**RE: *Green Mountain Falls County Documents Review Comments and Redlines***

EXISTING AND PROPOSED DRAINAGE MAP

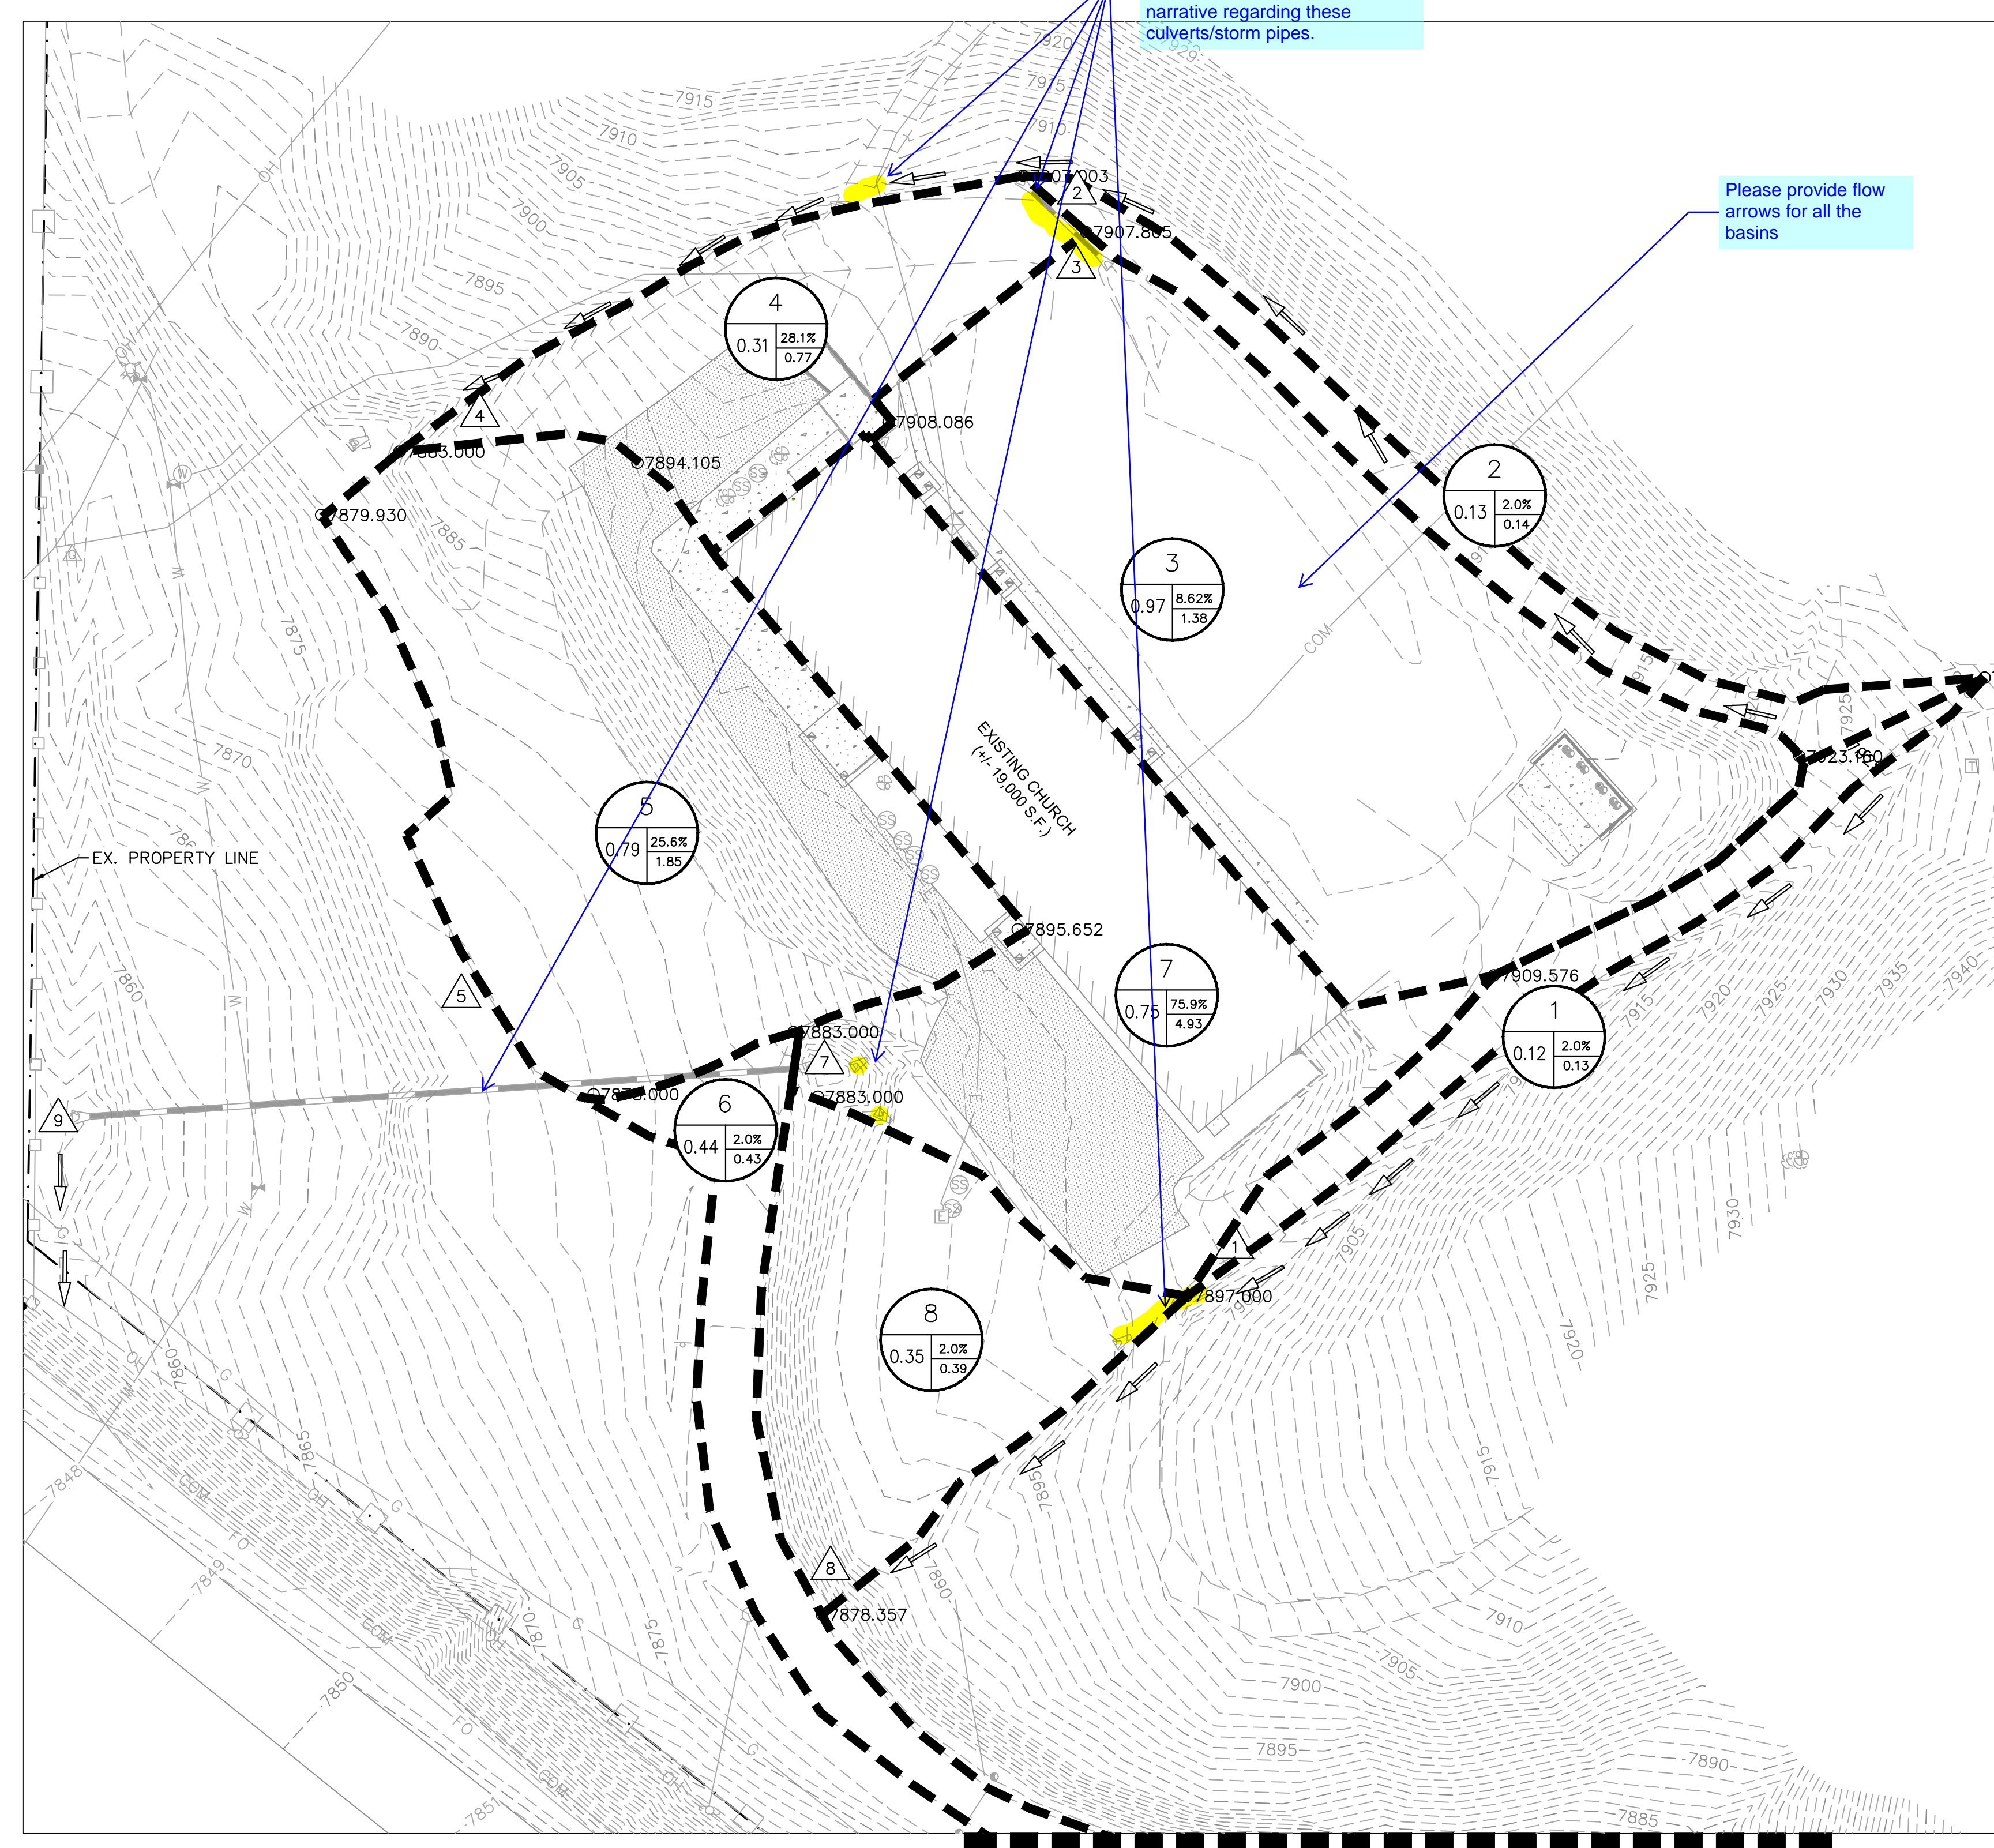
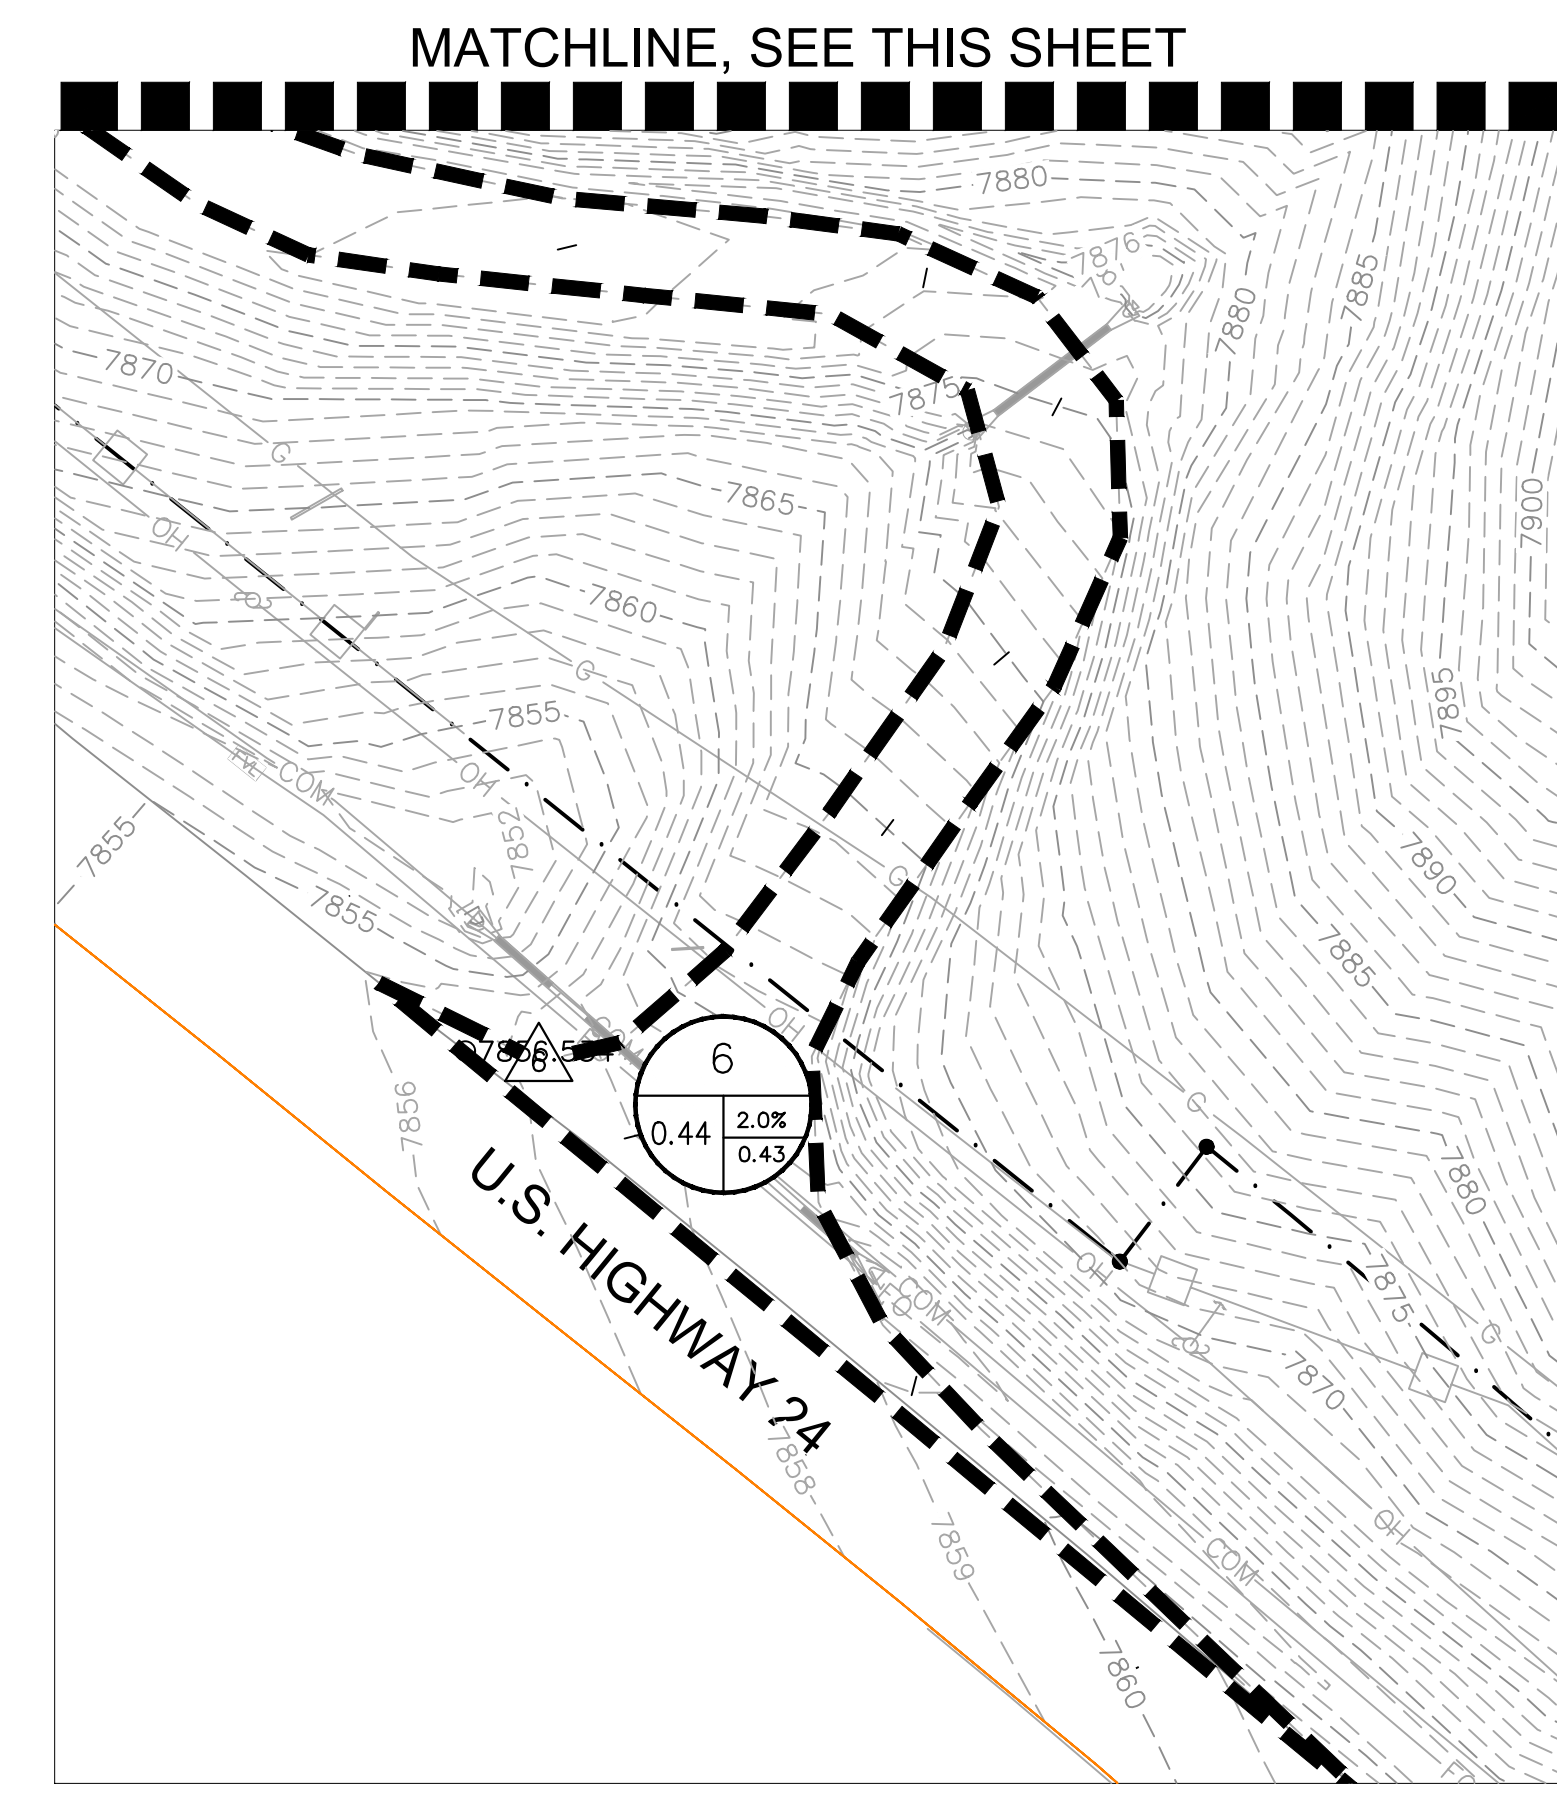
16. Show and label all existing culverts/storm pipes, providing their size and type. Include discussion in the narrative regarding these culverts/storm pipes.

17. Provide flow arrows for all the basins.

*Response: Noted.*

*Response: Noted.*
